Re: Whether a portal frame shed for agricultural usage, 5.07m in height and site boundary revisions is or is not development or is or is not exempted development at Coolfore, Monasterboice, Co. Louth.

Planning Ref. No. S5 2018/58

An Bord Pleanála Ref: ABP-303810-19

APPEAL STATEMENT

REVISED BOUNDARY SITE PLAN.

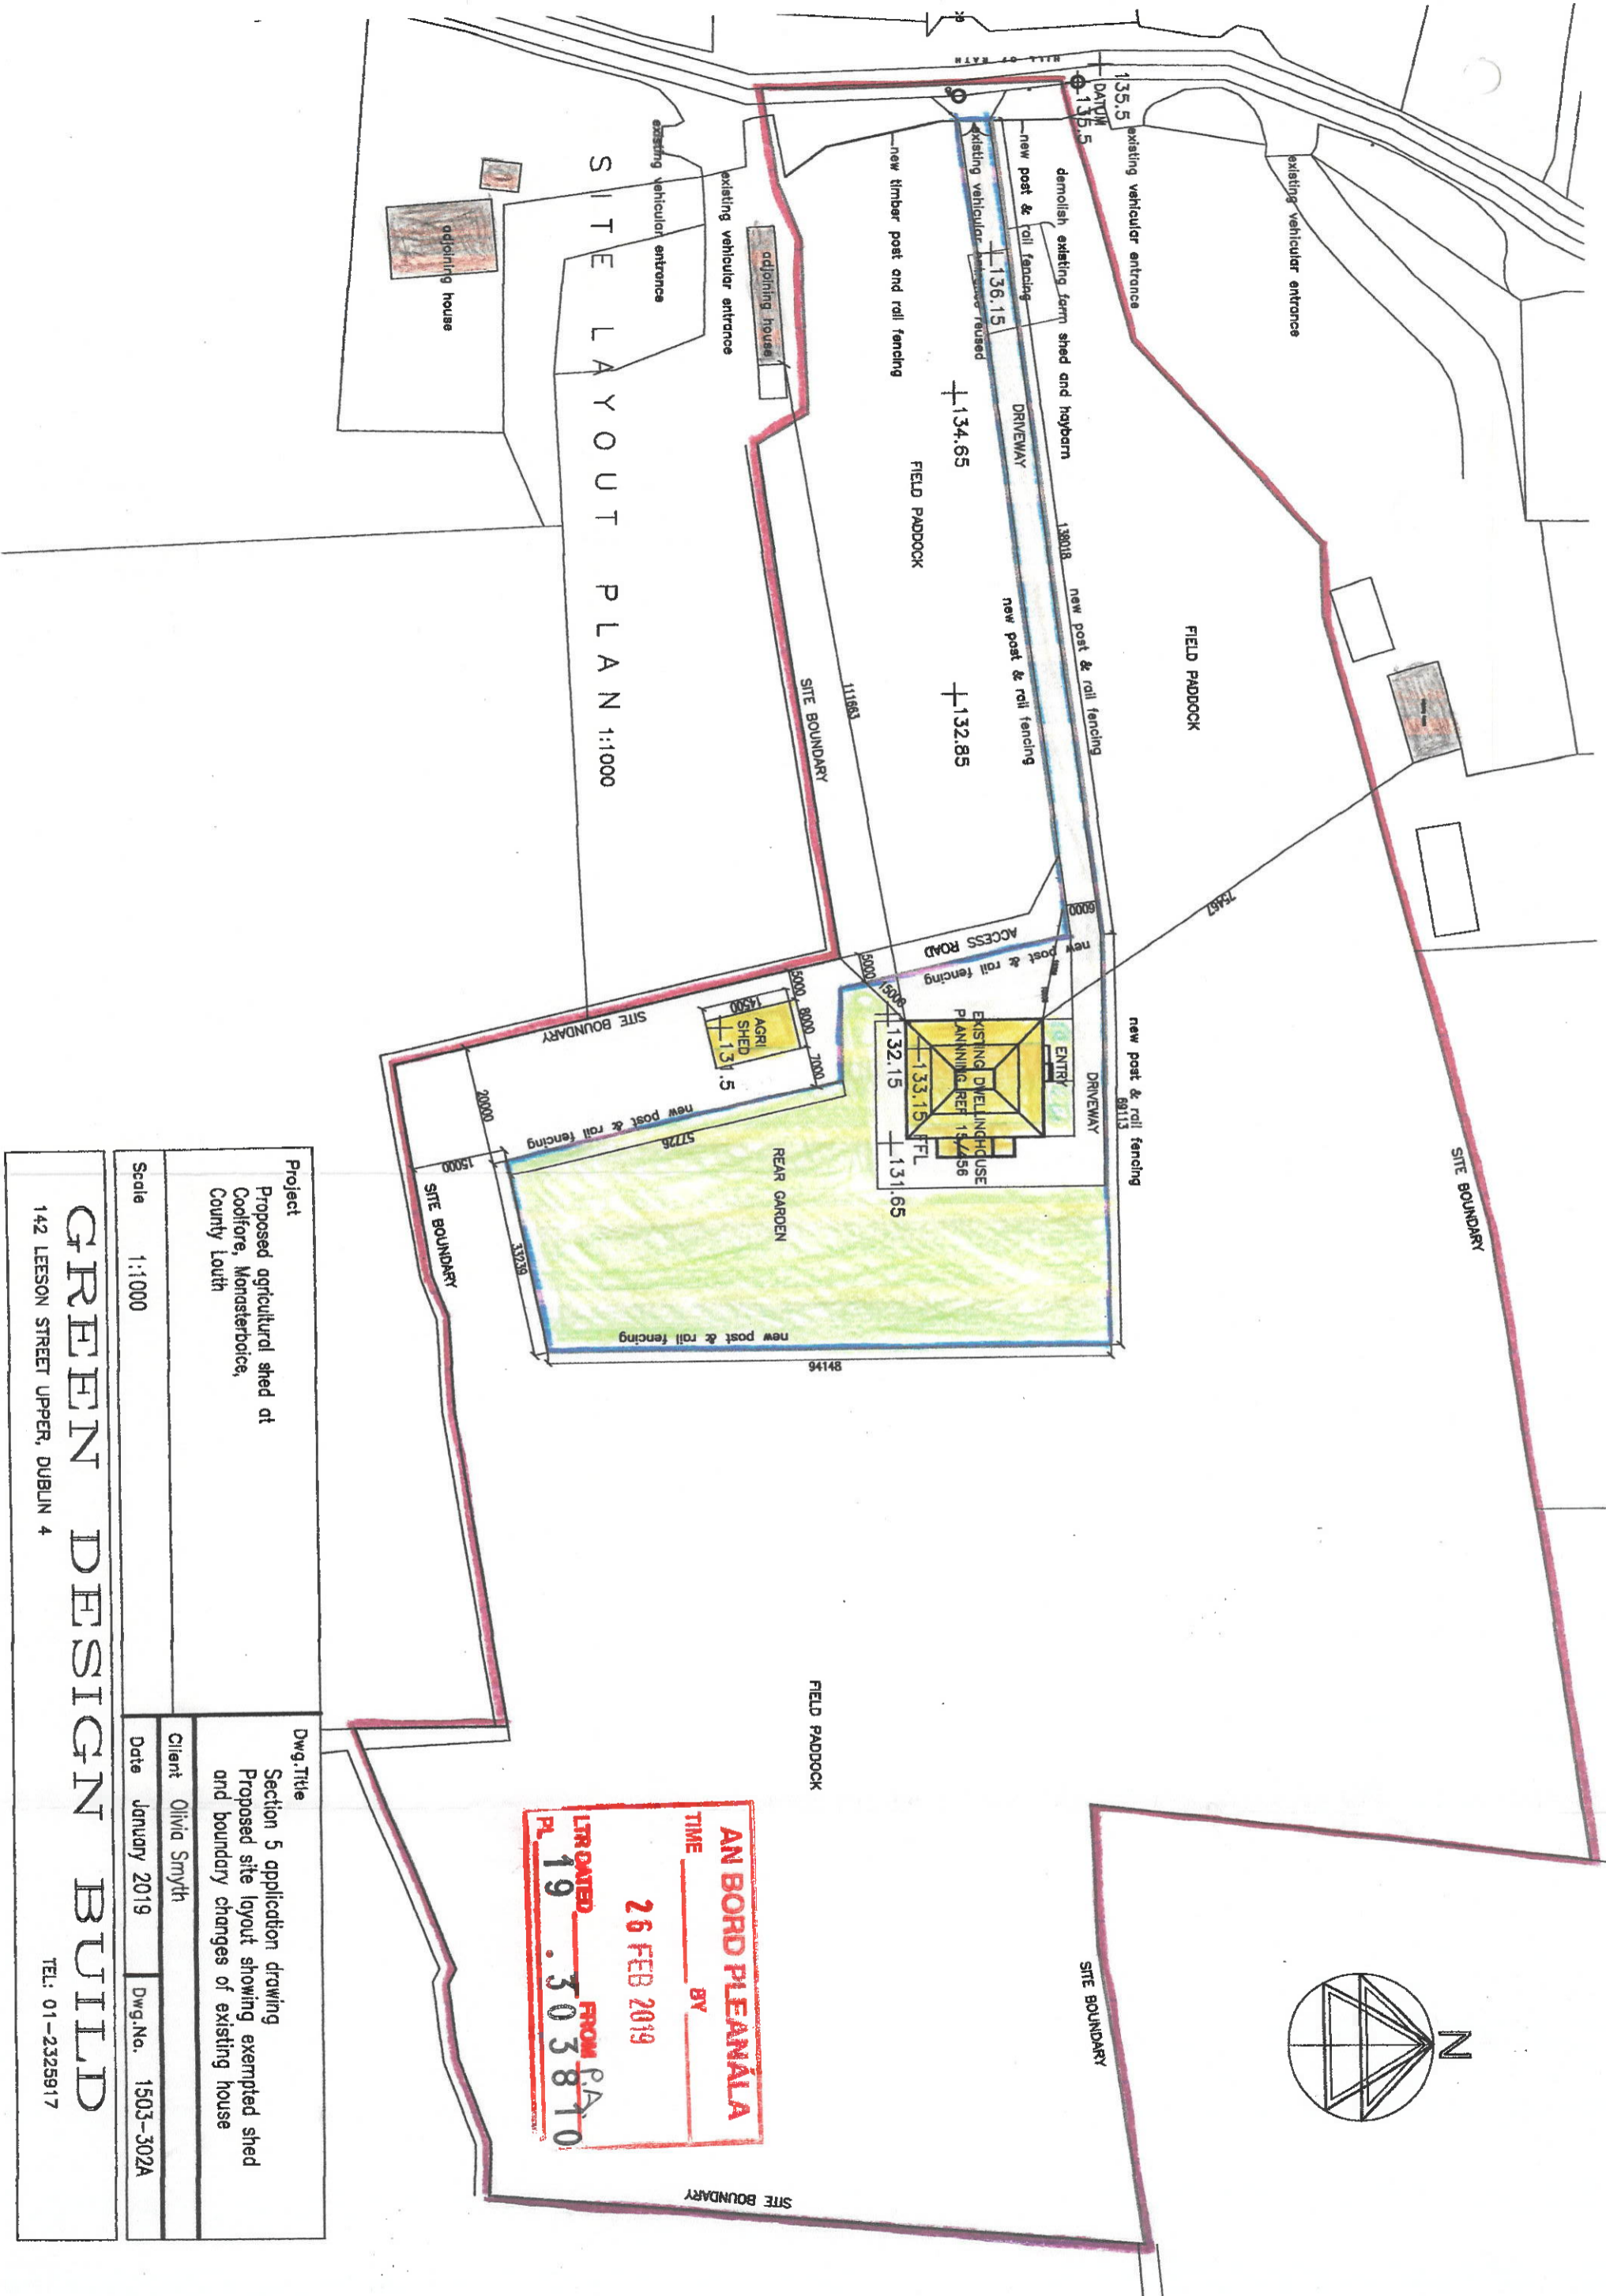
- Notwithstanding the above, no legal agreement has been submitted for consideration in relation to amending the site boundaries of the dwelling granted under planning reference 15/456 and no works have taken place on the ground. Thus the Planning Authority remains of the opinion that the shed is within curtilage of 15/456.

SITE/ROOF PLAN

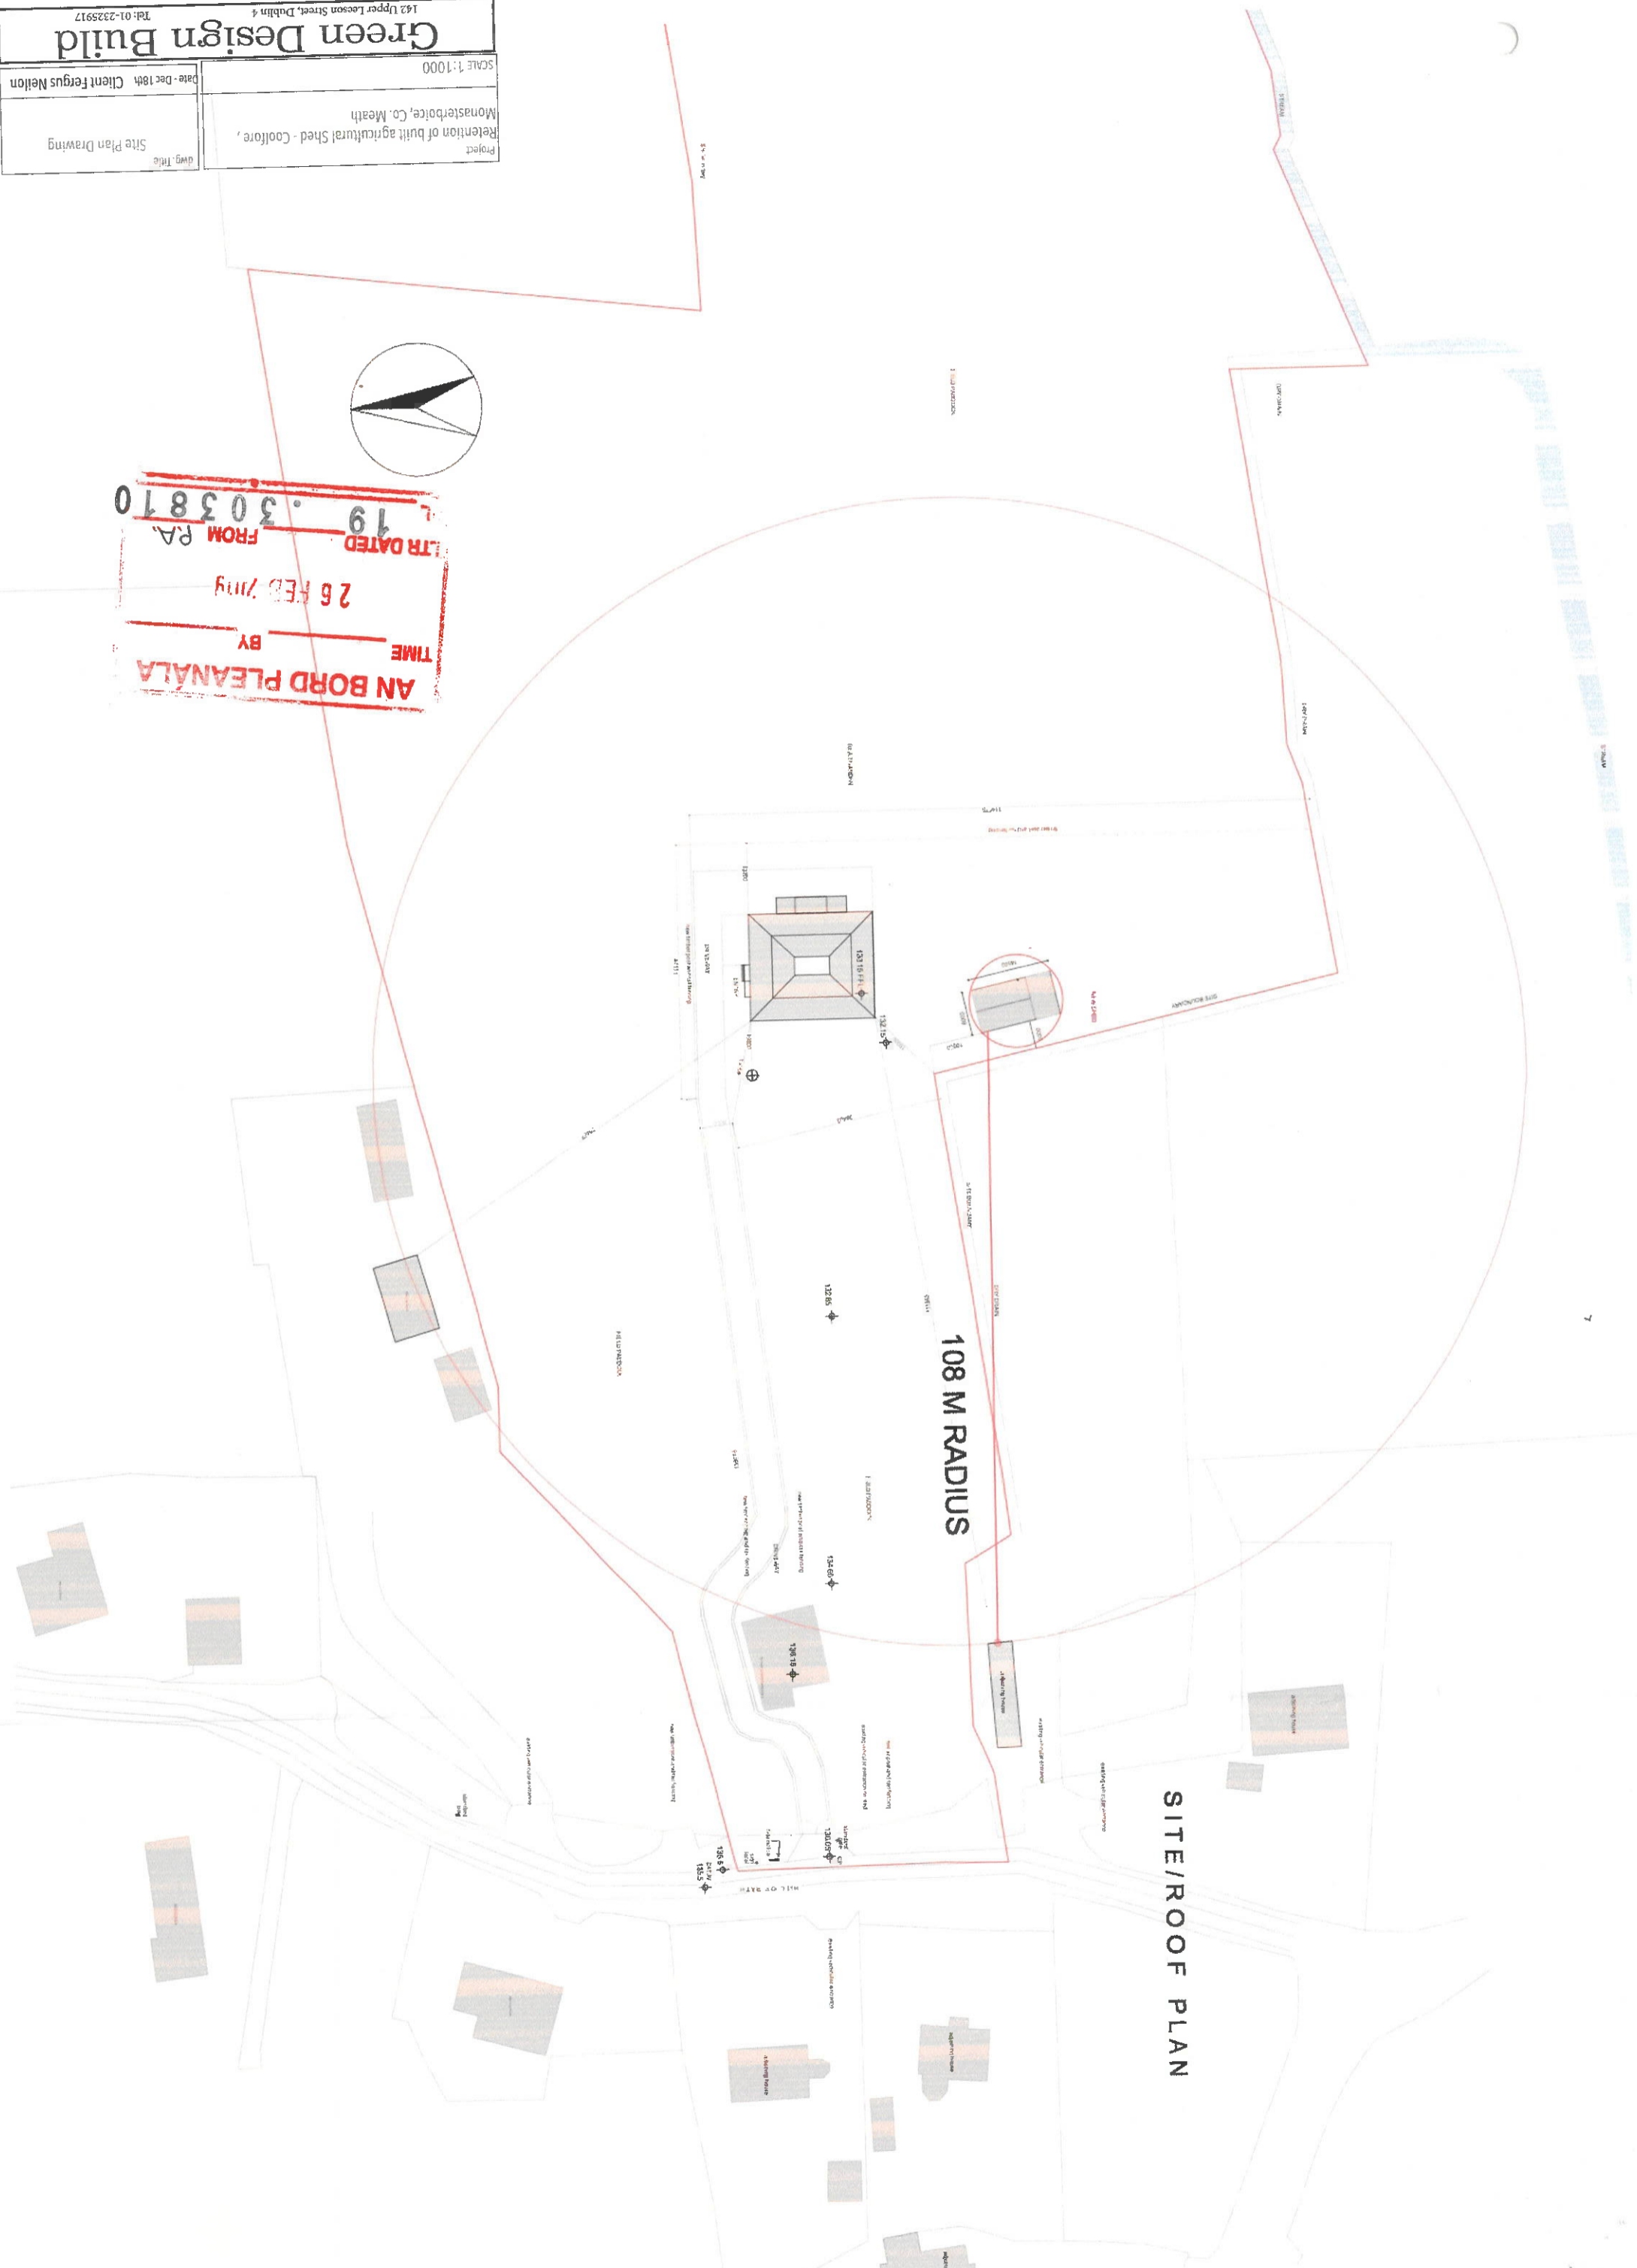
- The portal shed was refused on the basis that it was not considered be exempt under Schedule 2 Class 9, Condition/ Limitation No. 2 of the Planning and Development Regulations 2001 (as amended) in so far as the shed is not located within a farm complex nor within 100m of a farm complex. The shed is in fact located 112m from the existing farm complex. Thus the Planning Authority remains of the opinion that the shed cannot be considered exempt under Schedule 2, Class 9 of the Planning and Development Regulations 2001 (as amended).
